17 January 2022

**Application for non-material amendment following a grant of planning permission  
Town and Country Planning Act 1990  
10 Greycoat Place, London, SW1P 1SB**

On behalf of our client, Victoria Spaces (UK) Ltd, this application is made under the Town and Country Planning Act 1990. It seeks to make non-material amendments to the planning permission for the proposed redevelopment of 10 Greycoat Place, SW1P 1SB (hereafter known as 'the site') (Planning Application Ref: 20/05884/FULL).

S96a Planning - Proposed South Elevation

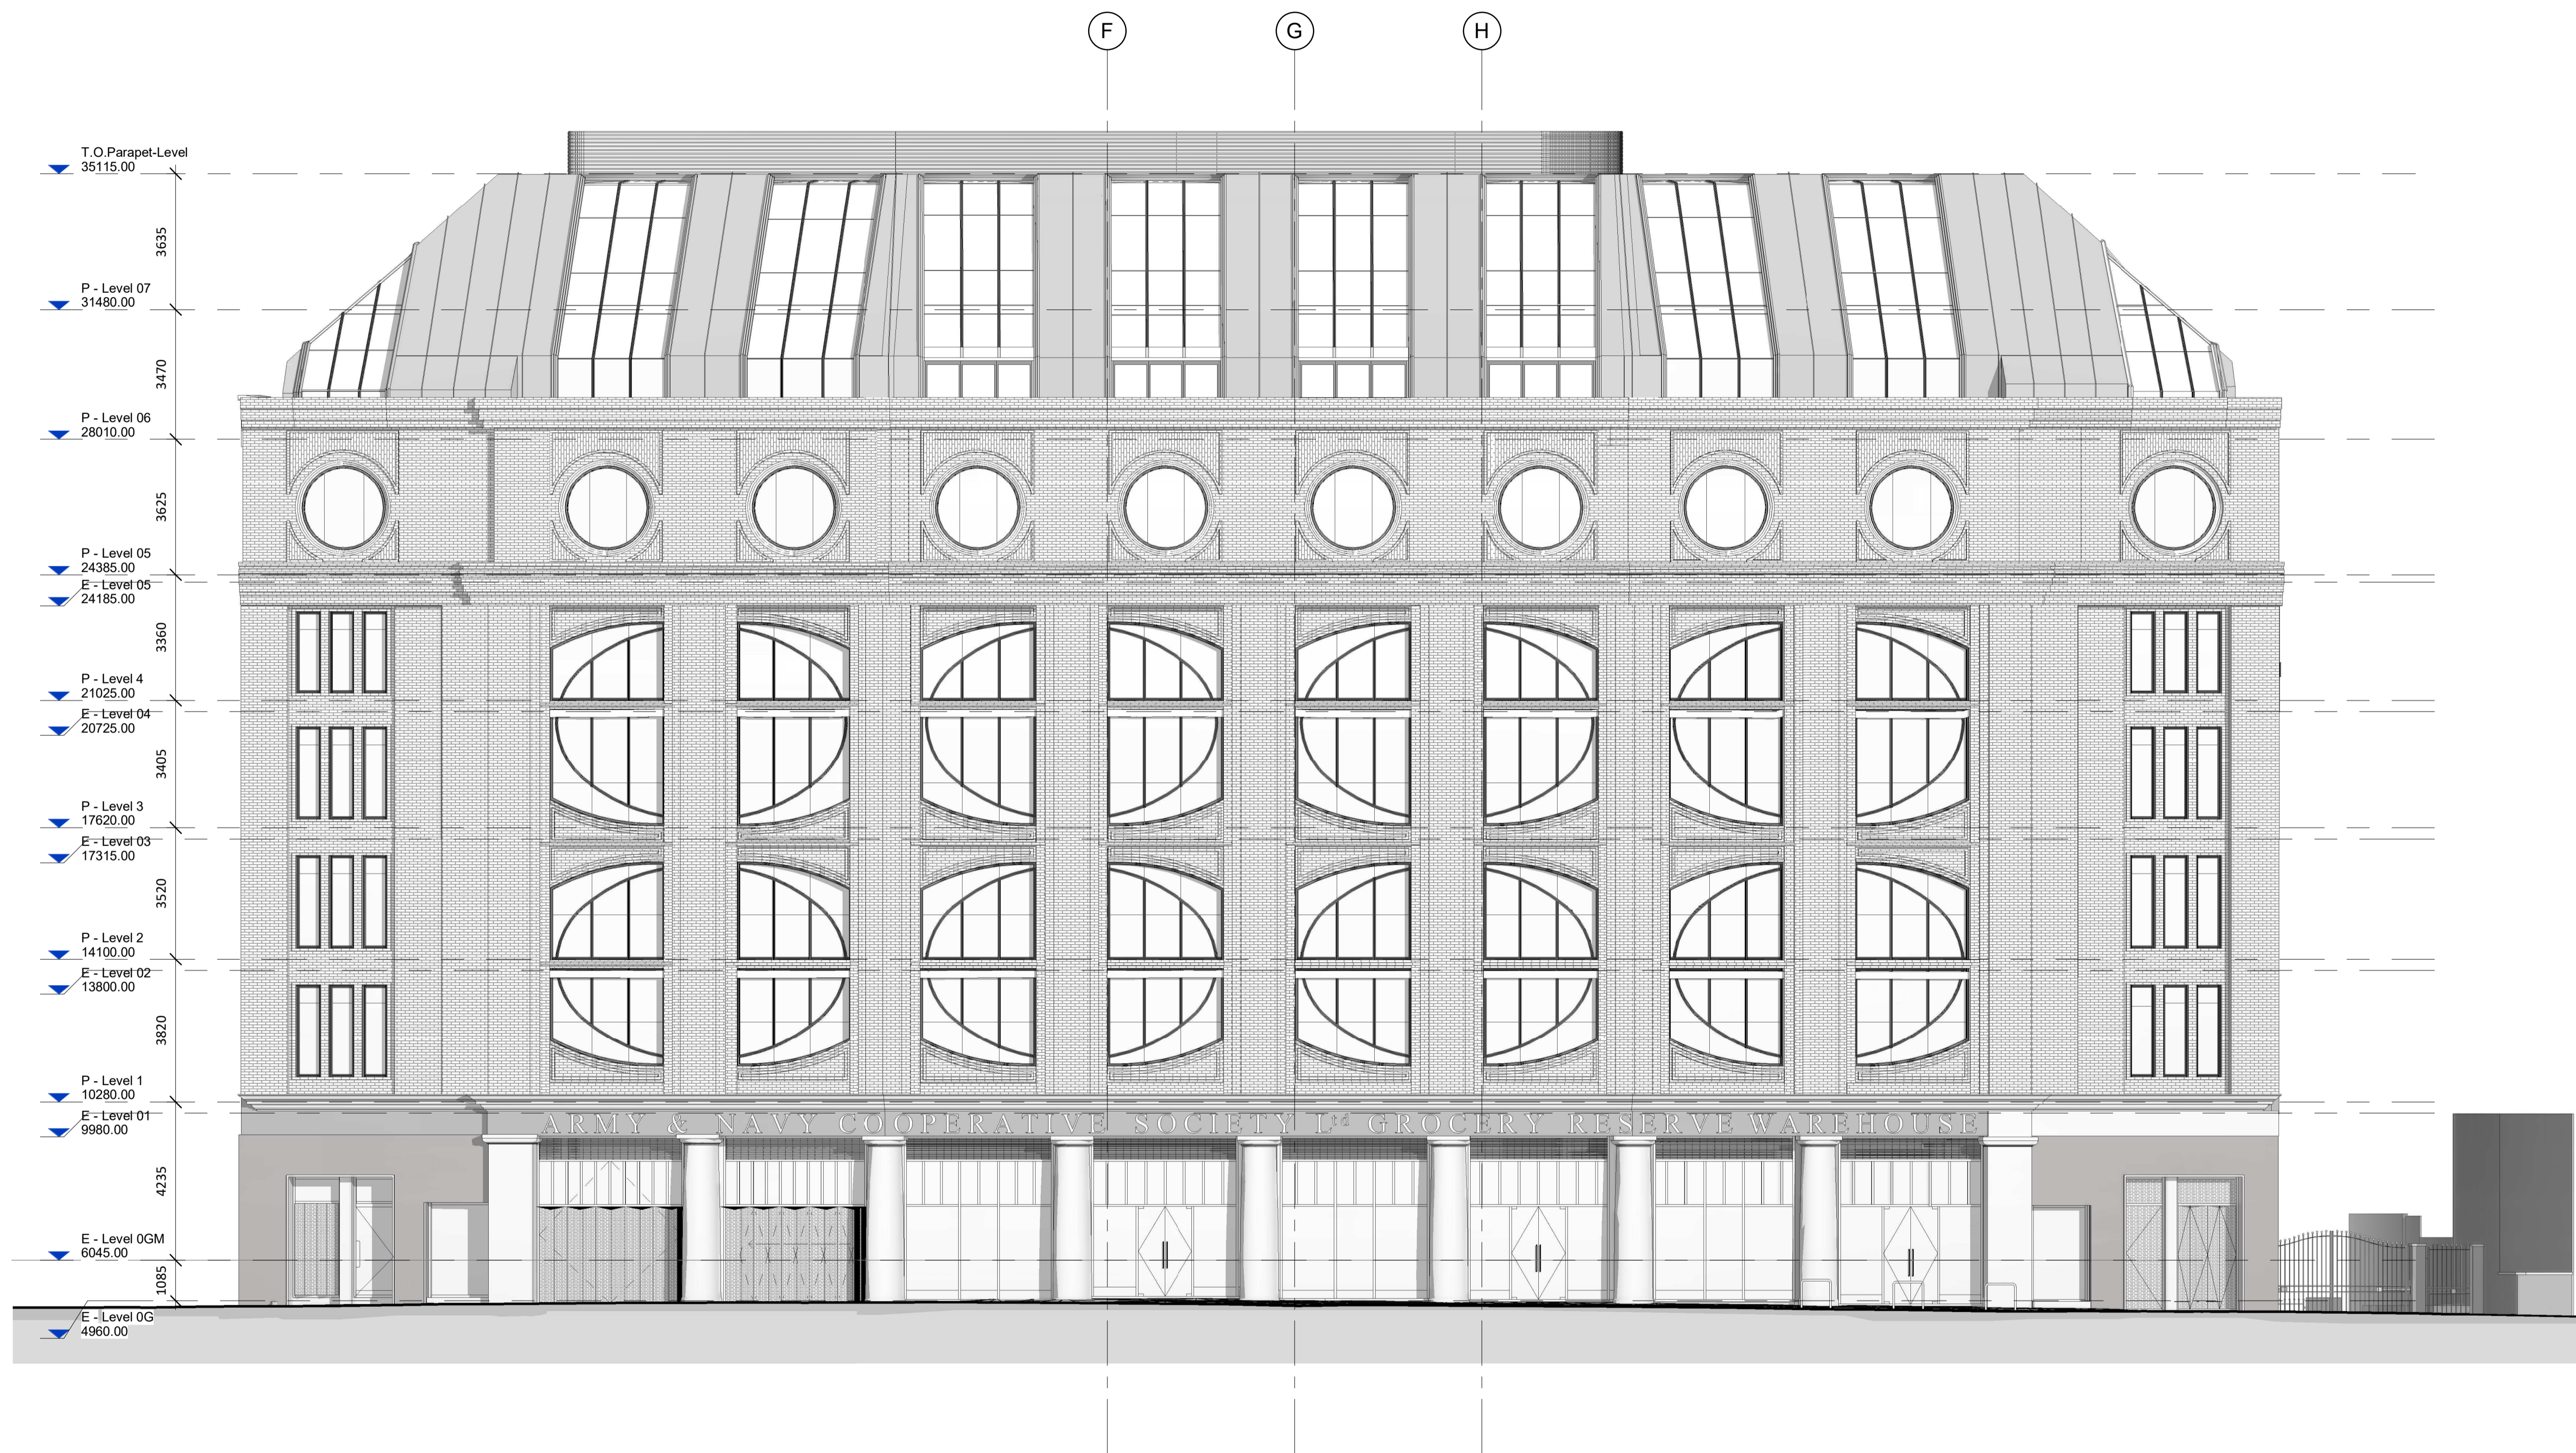
## Sixth Floor – Four windows on South Elevation

Non-material changes are proposed to four windows on the South facing elevation to propose four full height, *‘juliet balcony’* style windows. This will allow for greater ventilation of the office space and a sense of outdoor space for office occupiers.

Please note that officer occupiers will not be able to access the roof space fronting Greycoat Place due to balustrades within each of the four glazed units preventing them from doing so. The roof will remain as access only for maintenance purposes in accordance with Condition 10 of Planning Consent Ref: 20/05884/FULL.

SPPARC confirms that *‘to street level the adaption would remain unseen to immediate street level context due to the high level subservient sixth floor envelope being set back from the building perimeter.’*

Drawing Title
S96a Planning - Proposed Roof Floor Plan

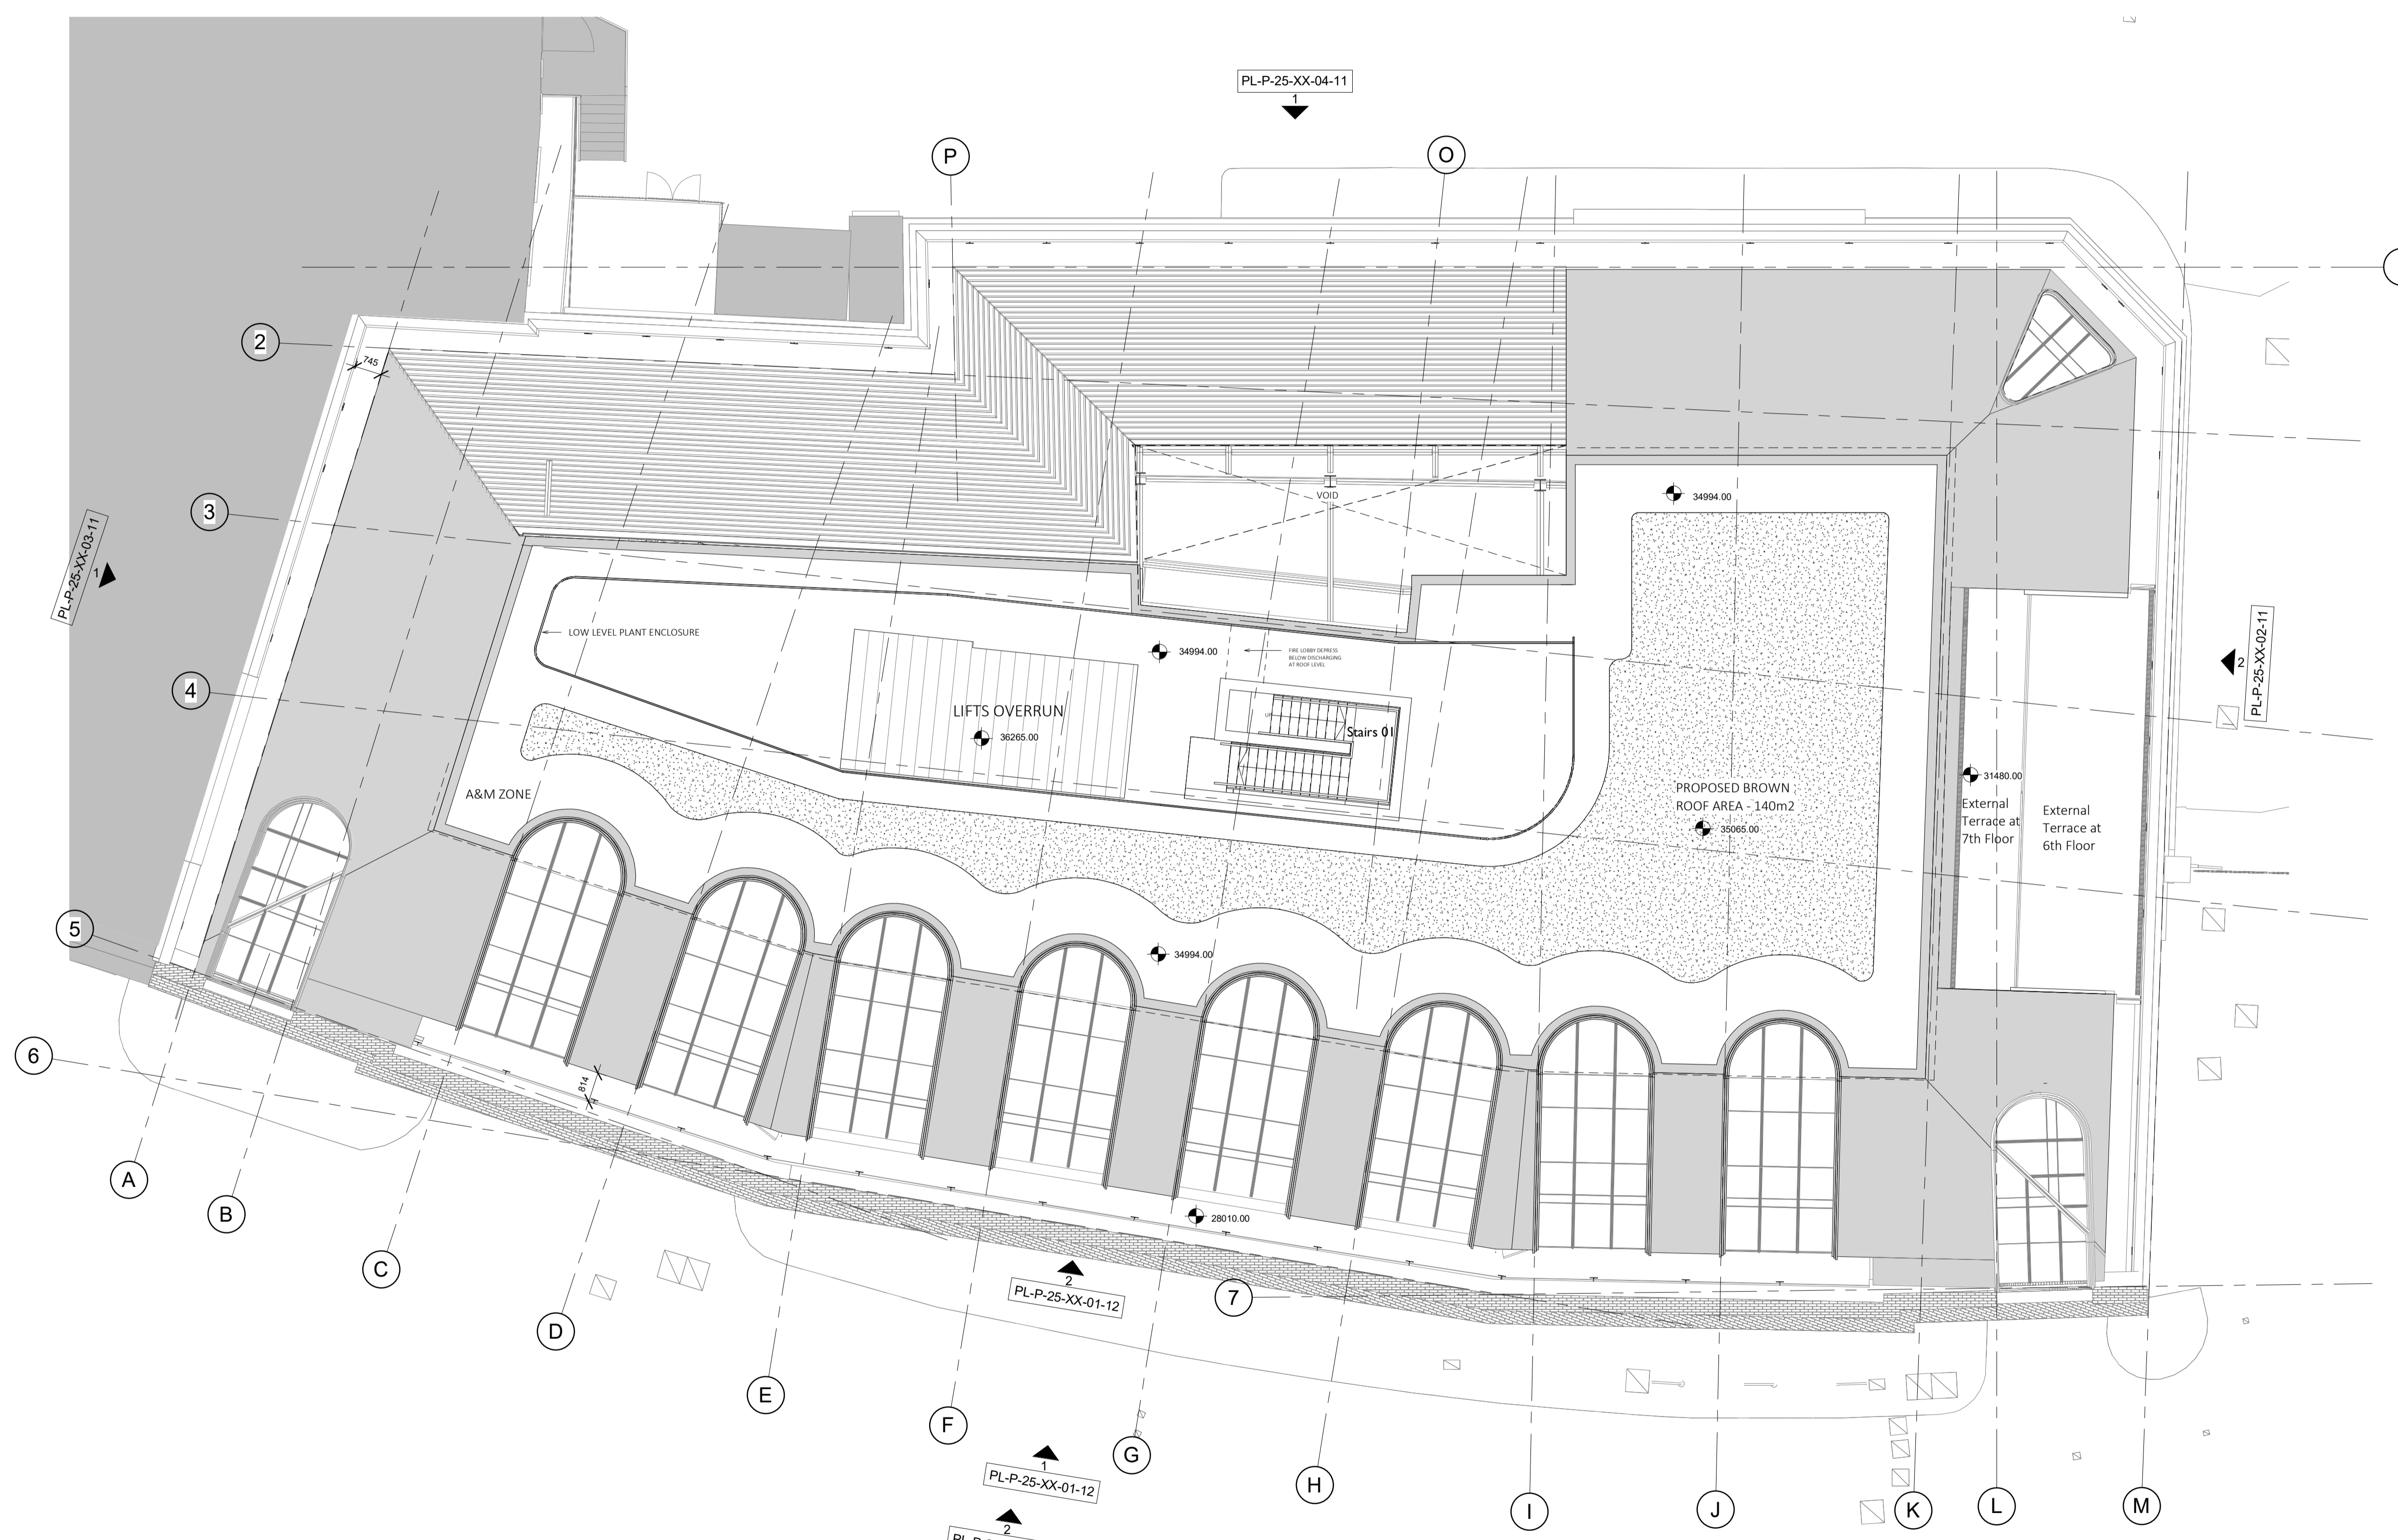
## Sixth Floor, Seventh Floor and Roof Level

Non-material changes to the internal plant wall arrangement to provide better use of the internal office spaces on the sixth and seventh floors and resultant changes to the plant wall at roof level as shown on page 6 and page 8 of the submitted Design and Access Statement.
